PROJECT NO. PR-2021-005296

DESCRIPTION: Written Responses to DRB Comments

To:	Blaine Cater, PE – ABC Water Utility Authority
From:	Fred C. Arfman, PE – Isaacson & Arfman, Inc.
Date:	May 14, 2021
Regarding:	DRB Project: PR-2021-005296; SD-2021-00058 – Preliminary/Final Plat

<b>DRB Project No:</b>  PR-2021-005296	<b>Date:</b>  4/21/21	<b>Item No:</b>  #13
<b>Zone Atlas Page:</b>  H-15	<b>Legal Description:</b> Lot(s) TRACT 1-A1, MUELLER INDUSTRIAL, TRACT C4, LANDS OF MENAUL SCHOOL, INC.  <b>Location:</b> 720 CANDELARIA RD NE between CANDELARIA RD NE and MENAUL BLVD NE	
<b>Request For:</b> SD-2021-00058 – PRELIMINARY/FINAL PLAT

PLAT OF
TRACT 1A-1A
MUELLER INDUSTRIAL SUBDIVISION

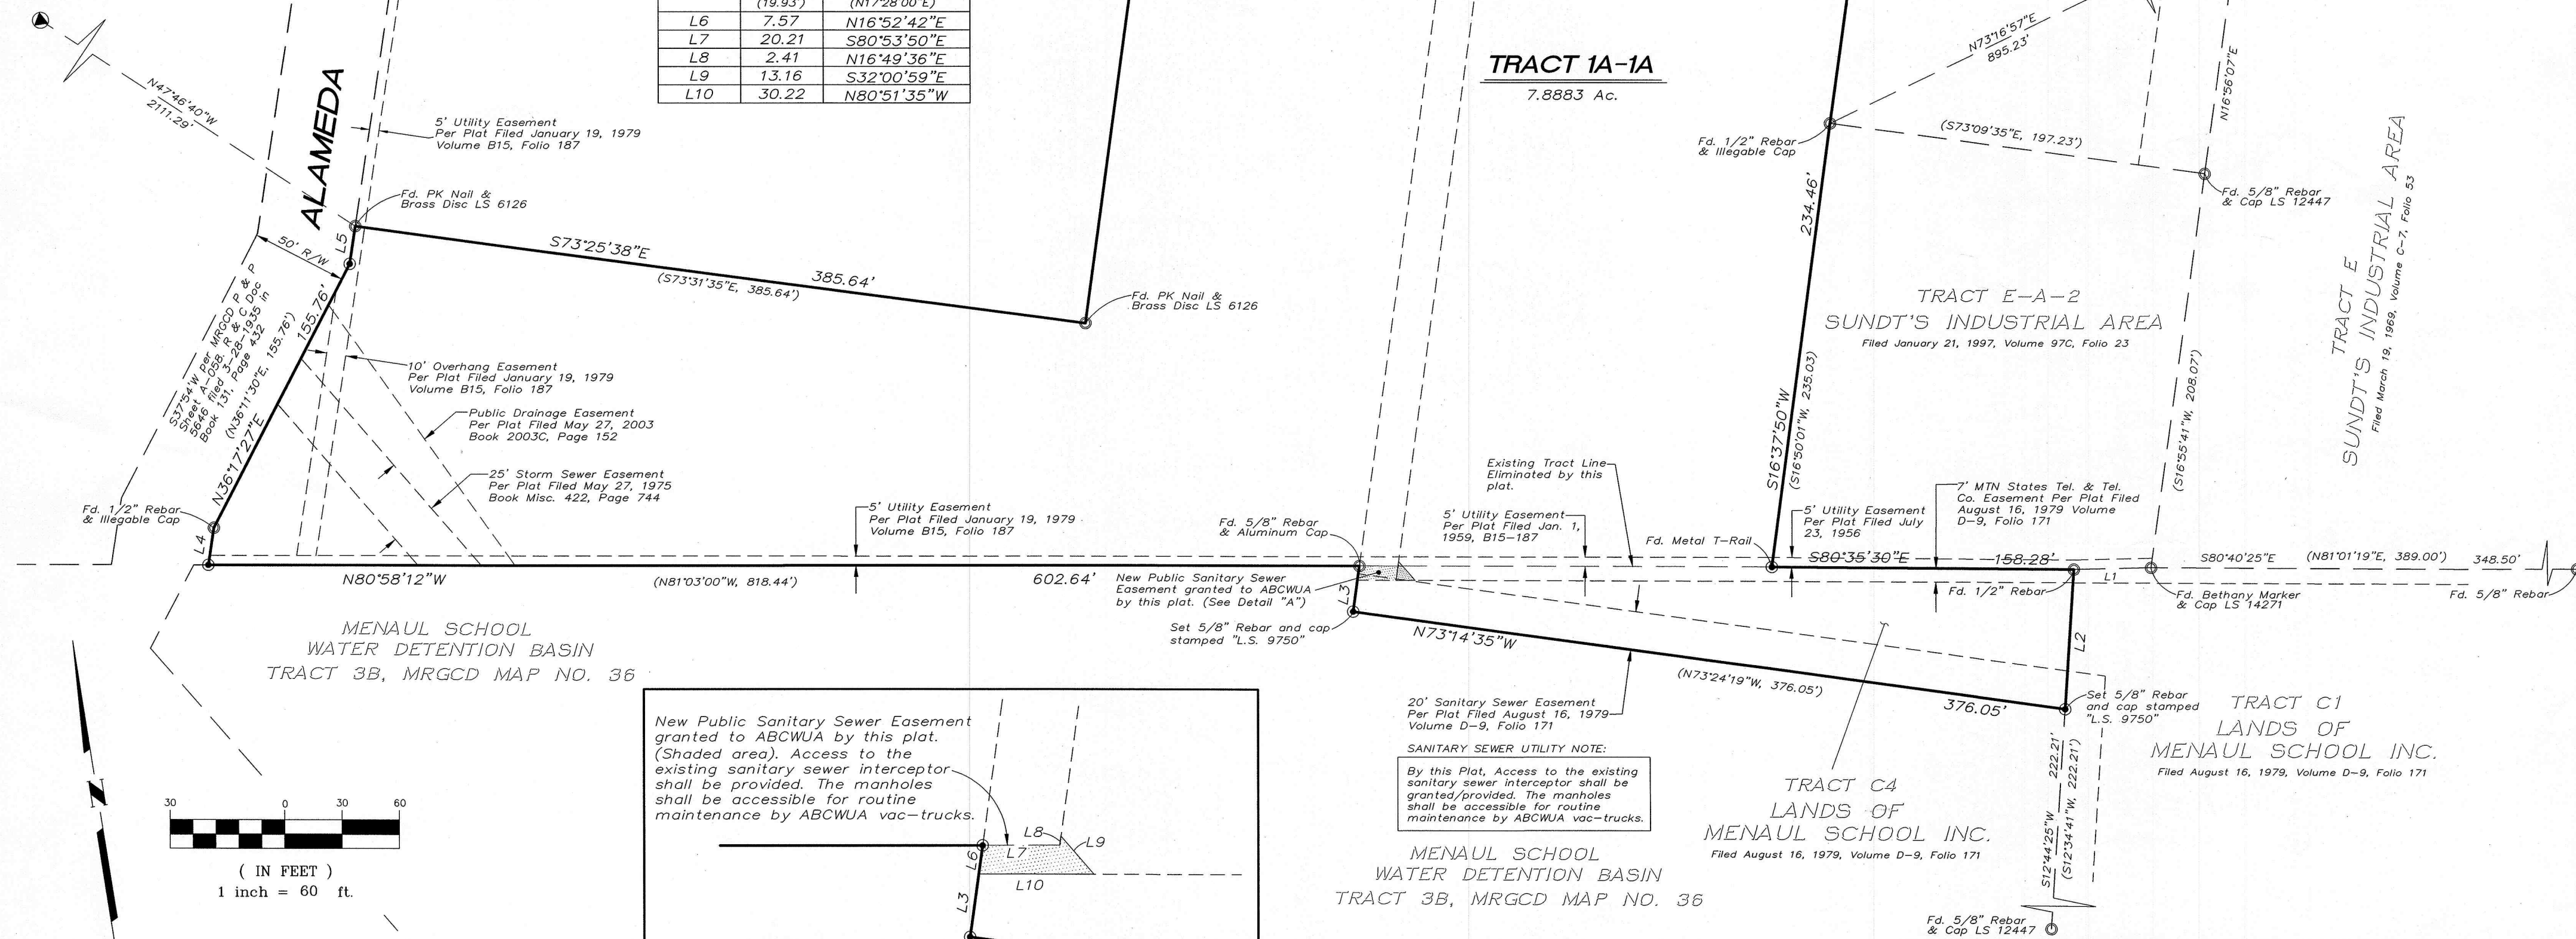
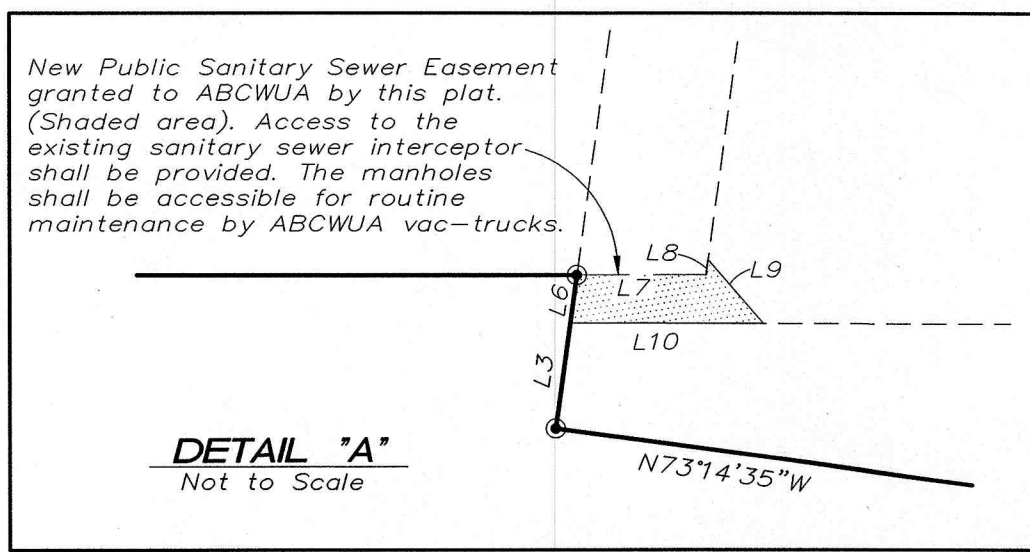
1. PREVIOUS COMMENT: The plat proposes a new 5 foot public utility easement within the existing ABCWUA public sanitary sewer easement. This location of the public utility easement is not allowed.
2. PREVIOUS COMMENT: Prior to ABCWUA approval, please coordinate with NM811 to confirm the location of the sanitary sewer interceptor is within the platted easement.
  - a. Provide an exhibit that locates the structures in close proximity to the public sanitary sewer easement.

1. The 5' PUE that was proposed within the existing ABCWUA public sanitary sewer easement has been removed from the plat.
2. The existing sanitary sewer interceptor was located from the original and supplemental surveys and shown on the Existing Conditions Exhibit. The exhibit was deemed acceptable at DRB.
3. The parcel will be incorporated into the storage facility limits as a paved area with no structures. A note was added on the plat allowing the ABCWUA to have access to the SAS interceptor for routine maintenance. The note was deemed acceptable at DRB.

EXISTING CONDITIONS EXHIBIT

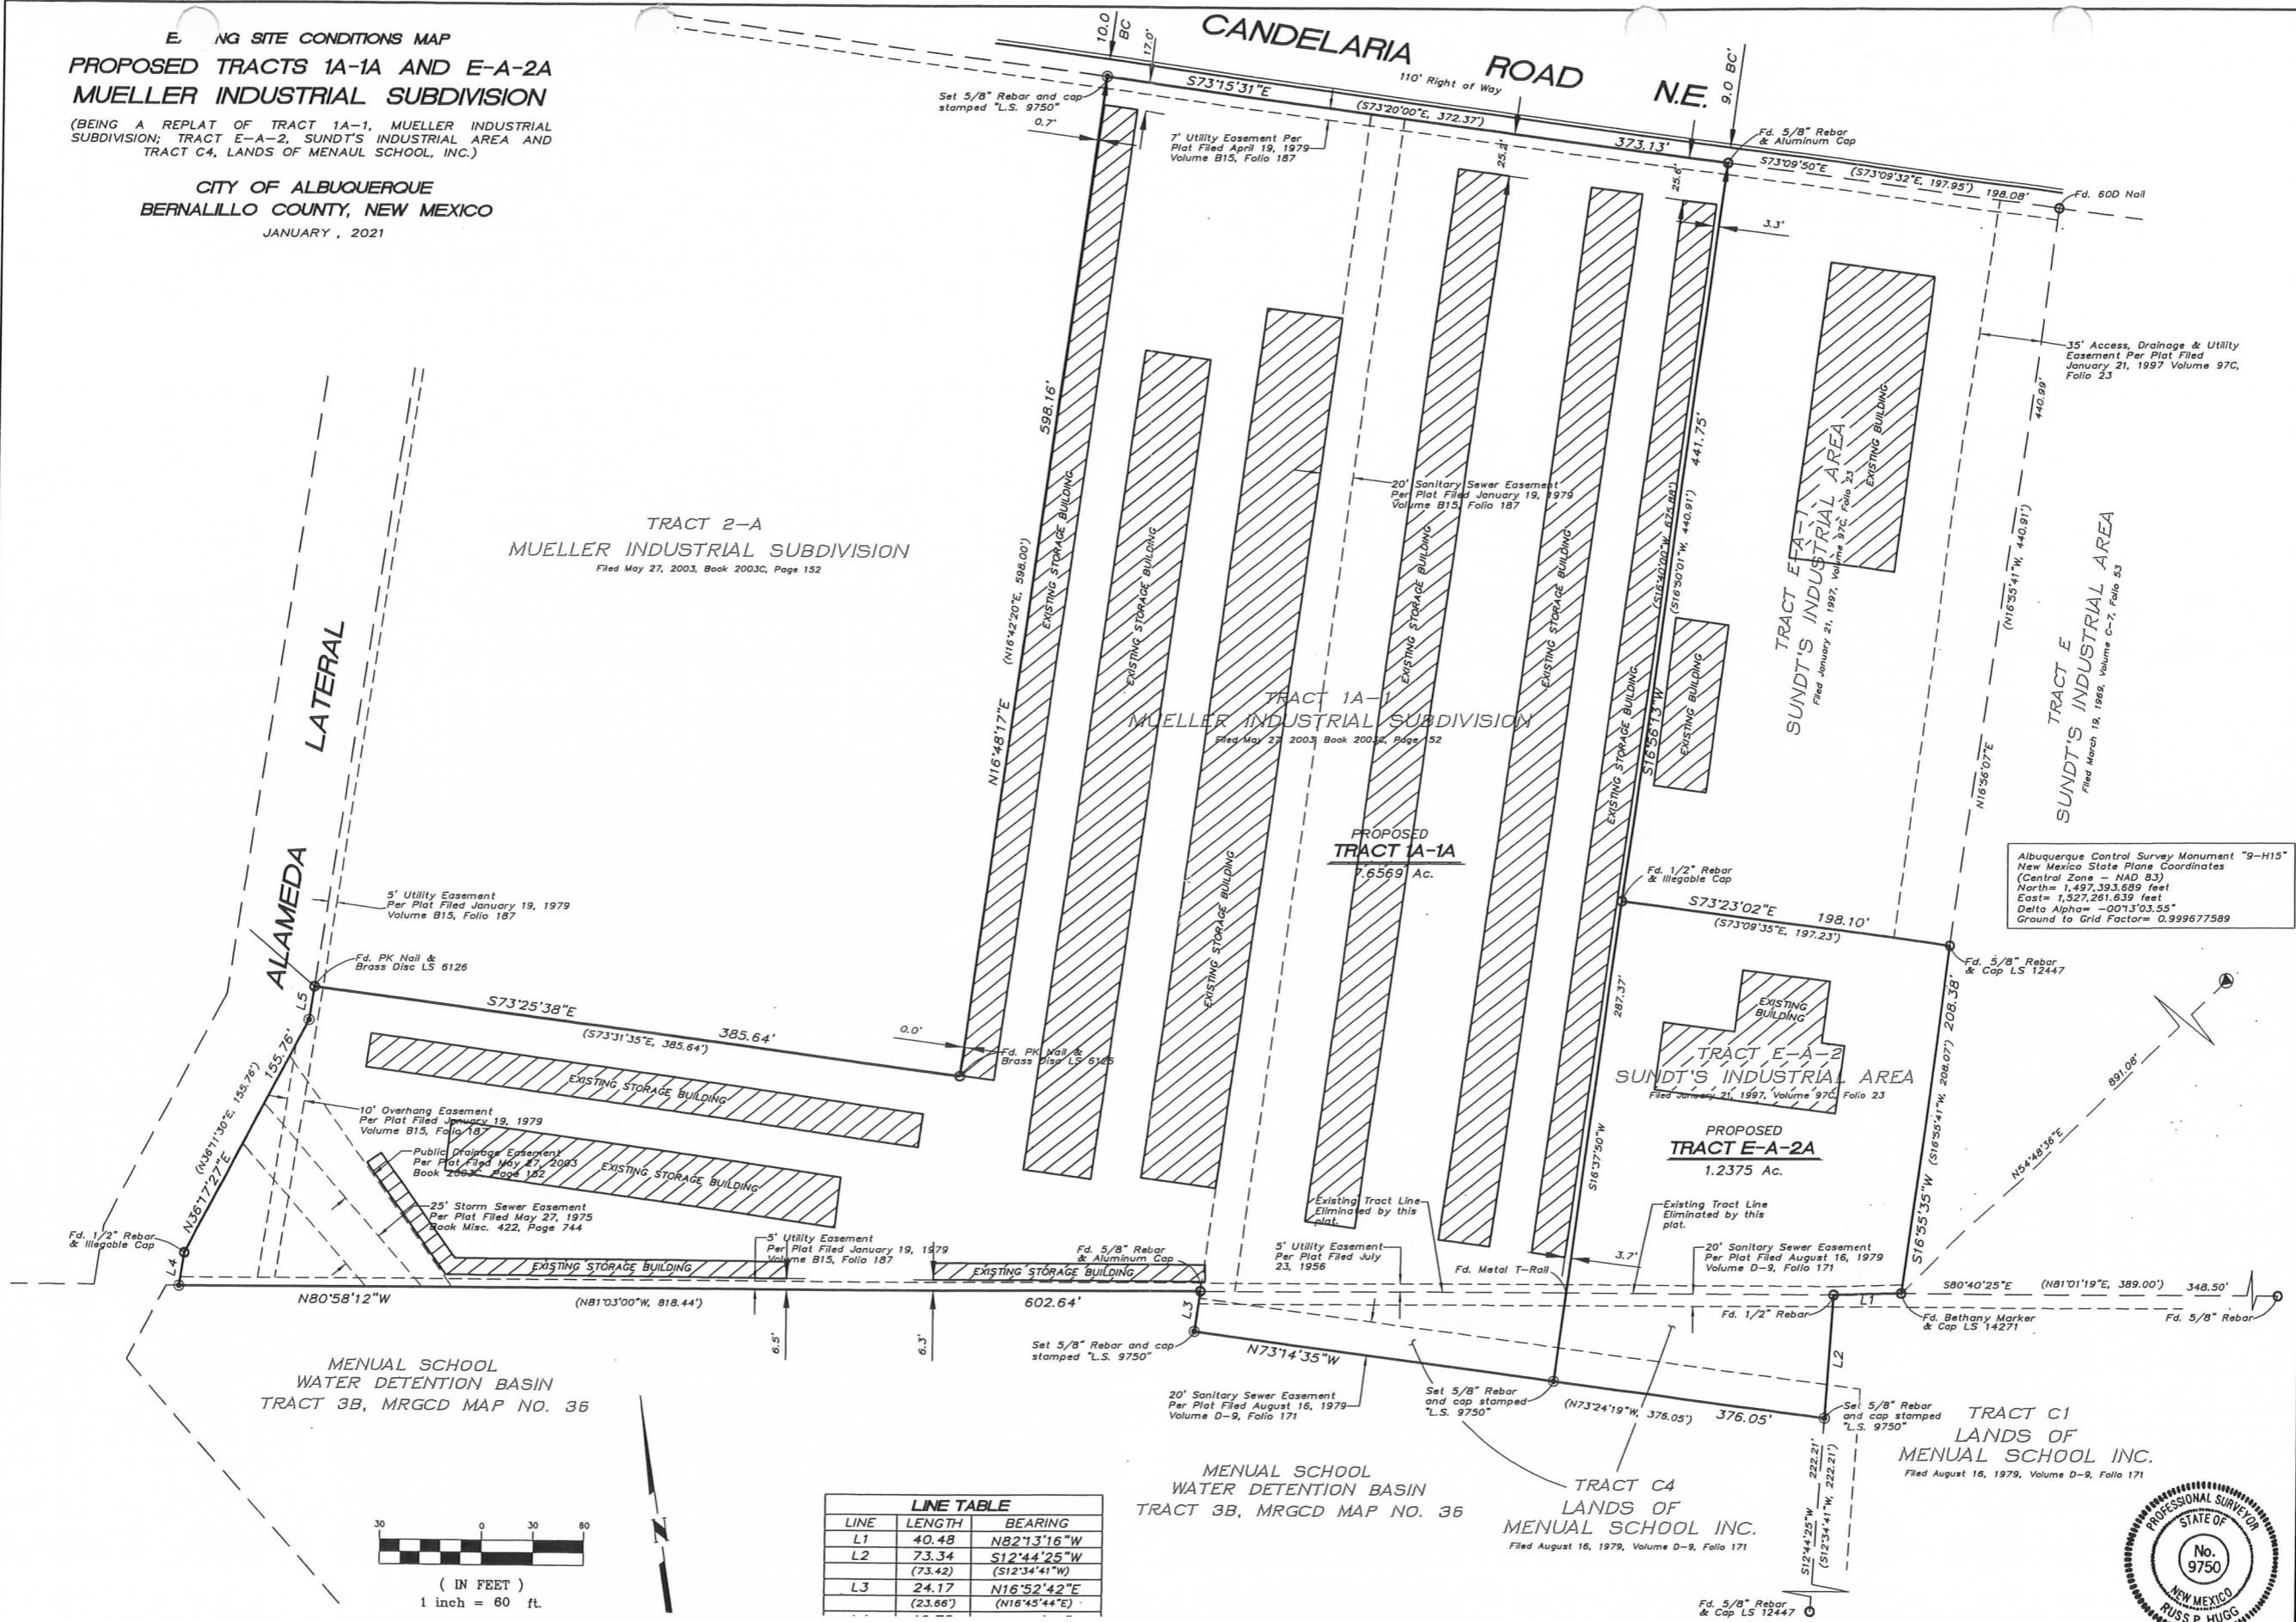
- b. Update: It was discussed at DRB that the exhibit could show surveyed manhole locations with straight line connections in lieu of the locate service.
3. PREVIOUS COMMENT: The easement and sewer line continues to the east along the consolidated parcel. Are there any development plans for the newly incorporated parcel?
- a. Provide a note on the plat that access to the existing sanitary sewer interceptor shall be provided. The manholes shall be accessible for routine maintenance by ABCWUA vac-trucks.
